**CITY OF ALBUQUERQUE
PLANNING DEPARTMENT
December 4, 2014
DRB Comments**

PROJECT # 1010282

APPLICATION # 14-70386

RE: Tract 43-C, Town of Atrisco Grant Unit 2

SKETCH PLAT TRACT 43-C, UNIT 2

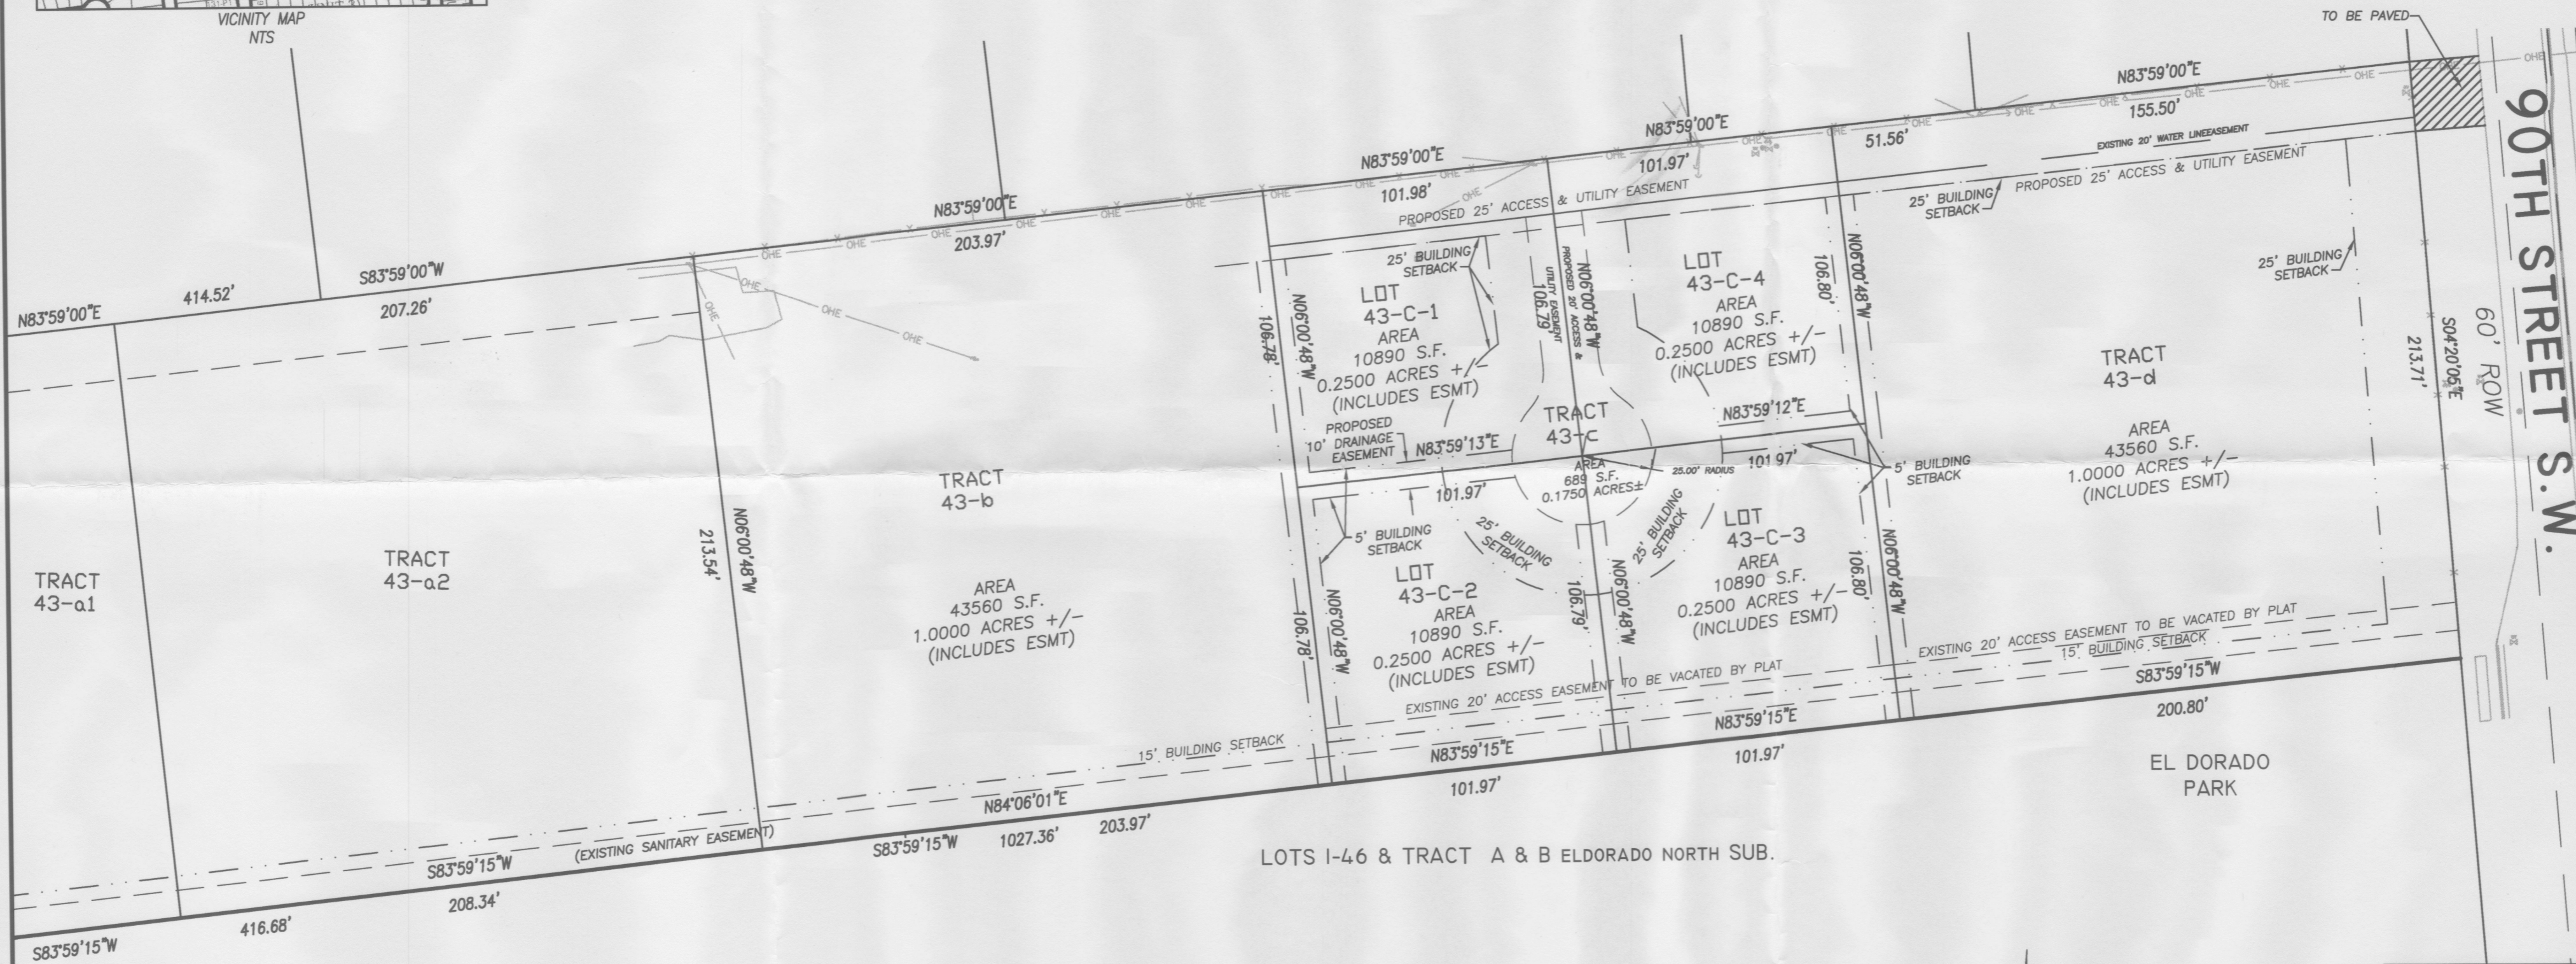
Calculations for net lot area (per the R-1 zoning requirements, minimum 6,000 sq ft) need to be provided. Local street standards would apply (see Transportation comments). Coordination with neighboring lots to provide more efficient platting is suggested.
